Date: 28th April 2025
Our Ref: PH/570/25
LPA Ref: H16-0437-24 (Original Approval)

S73 APPLICATION TO VARY CONDITION 2 OF THE APPROVED APPLICATION (REF: H16-0437-24) TO ALLOW FOR THE PROVISION OF PV PANELS TO THE ROOF OF THE CARE HOME AND THE MINOR CHANGE TO THE SHAPE OF THE PROPOSED EXTENSION, ASHWOOD CARE HOME, 43 SPALDING ROAD, SPALDING COMMON, LINCOLNSHIRE, PE11 3AU.

Proposed Site Plan

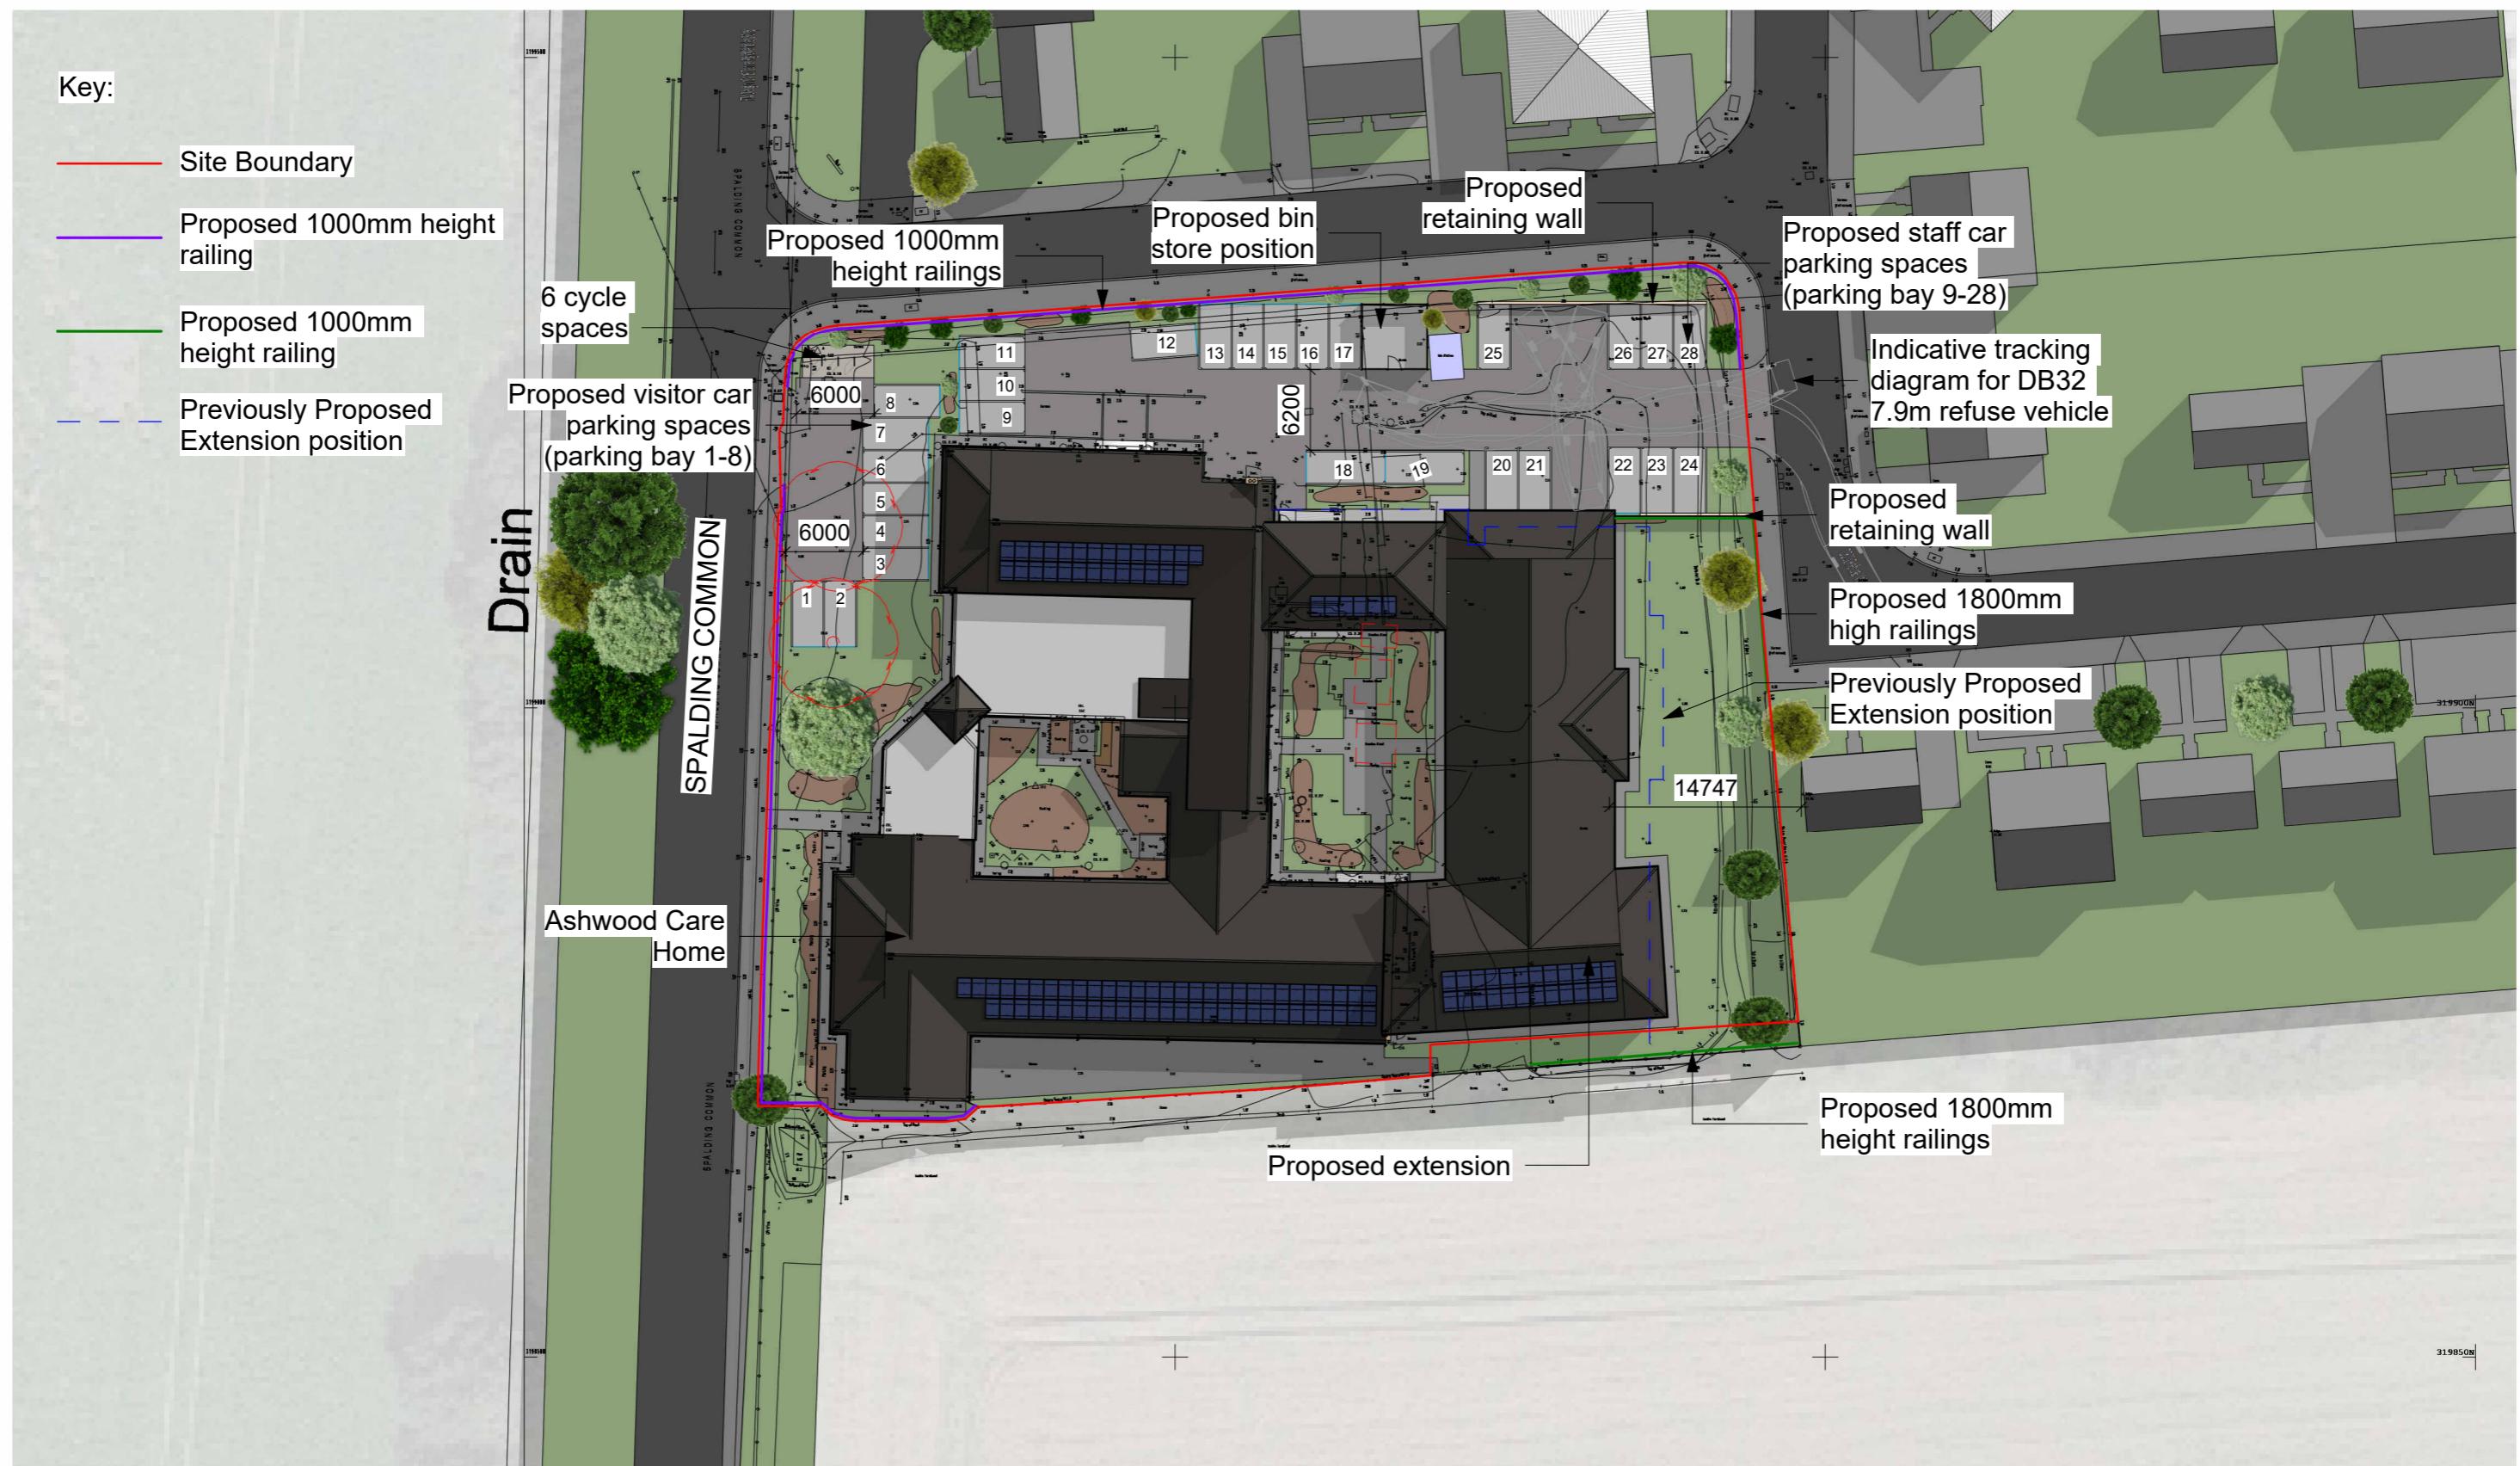
However, it has just come to light that part of the southern boundary to the site was incorrectly shown on the drawings submitted as part of the original planning application. The eastern end of the southern site boundary actually 'kicks back' into the site, as can be seen on the submitted drawing, meaning that the approved extension to the care home cannot be constructed as originally approved, as there would not be space for it, and the associated pathway, within the application site.

On this basis, the Architect has had to amend the drawings to show the boundary in its correct location as well as angling the southern part of the extension so as that this part of the approved development is entirely within the application site, as per the plan below. For convenience, I have added the approved part of the extension to this in yellow so that an instant comparison can be made.

In making these changes the Architect has managed to re-orientate this part of the extension slightly, without losing any bedroom space within. A revised set of plan and elevational drawings are submitted as part this application, and the 'red line' boundary has been amended accordingly.

In addition to this, the Applicants are looking to site circa 113 PV panels on the proposed and existing roofs of the care home structure, in order to generate a degree of power for the property, which will aid in the overall sustainability of the development. The location of these panels, which are all to be sited on south facing roof slopes, are shown on the submitted site layout plan.

| Drawing Title: | Proposed Elevations                                                           |

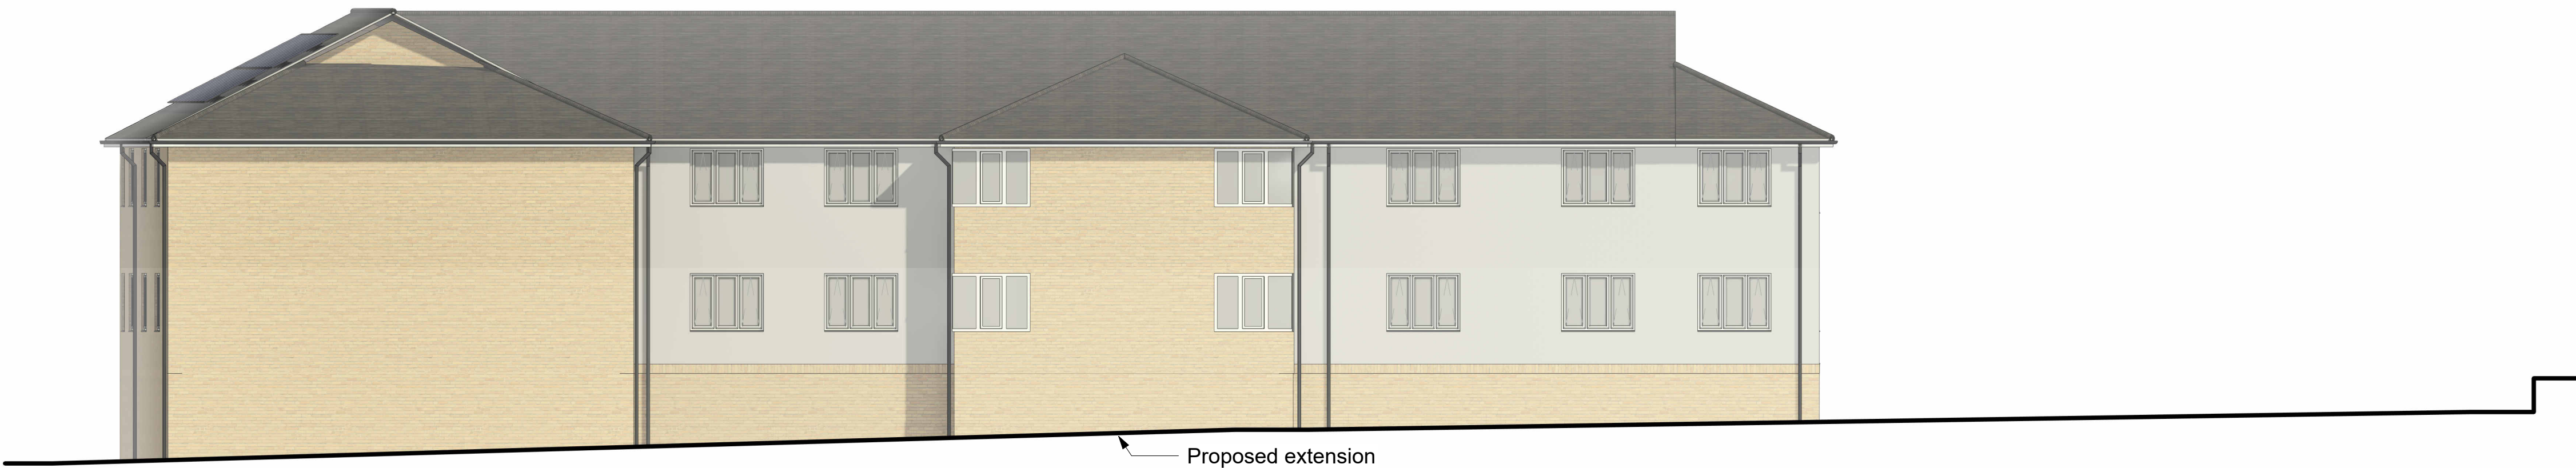
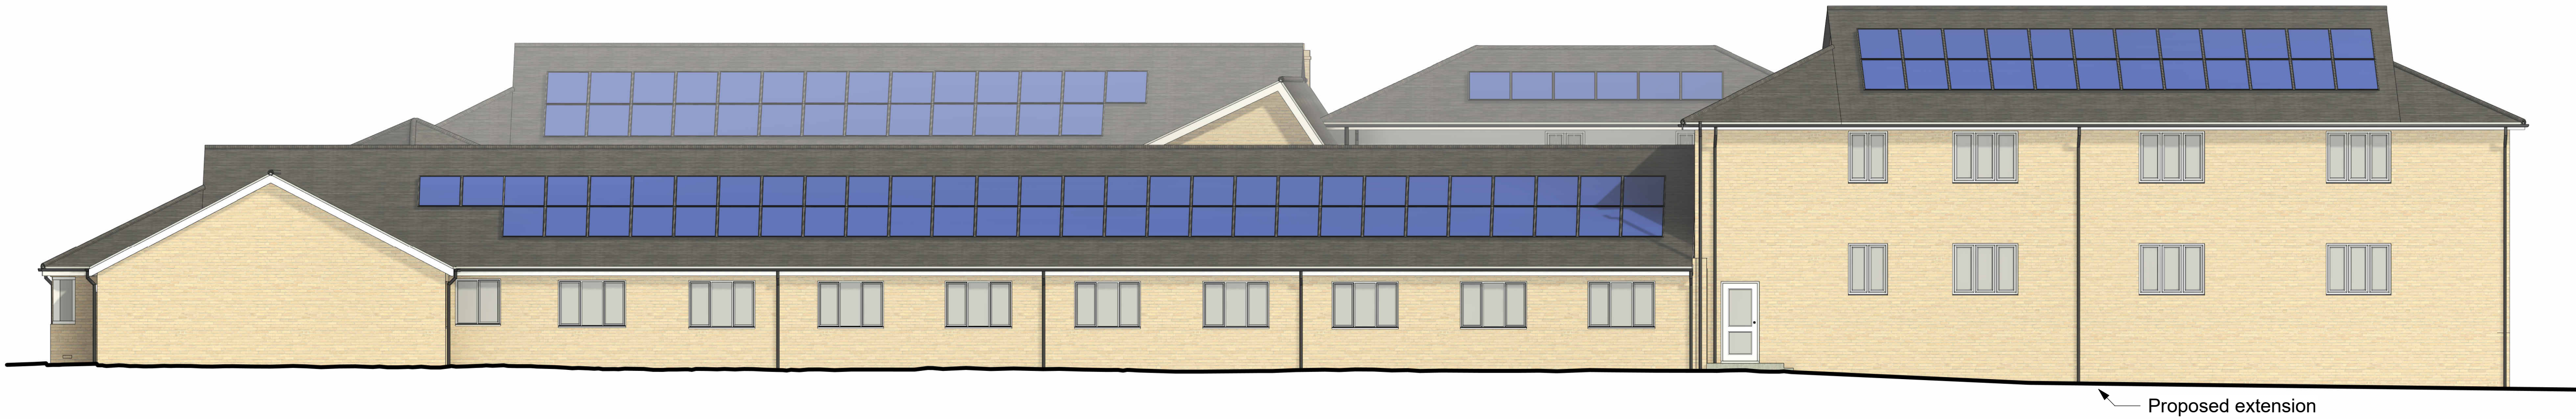
Condition 2 of the decision notice ties the development to the plans/drawings that were approved and lists these as set out on the following page. The drawings that are shown in red are those that need to be revised in order to show both the PV panels to the roof and the proposed amendment to the southern part of the approved extension, in order to allow for the correction to the southern site boundary.

- 0443 (10)001 - Site Location Plan
- 0443 (10)002 - Proposed Site Plan
- 0443 (20)001 - Proposed Ground Floor Layout
- 0443 (20)002 - Proposed First Floor Layout
- 0443 (21)001 - Proposed Elevations
- 0443 (21)002 - Proposed Courtyard Elevations
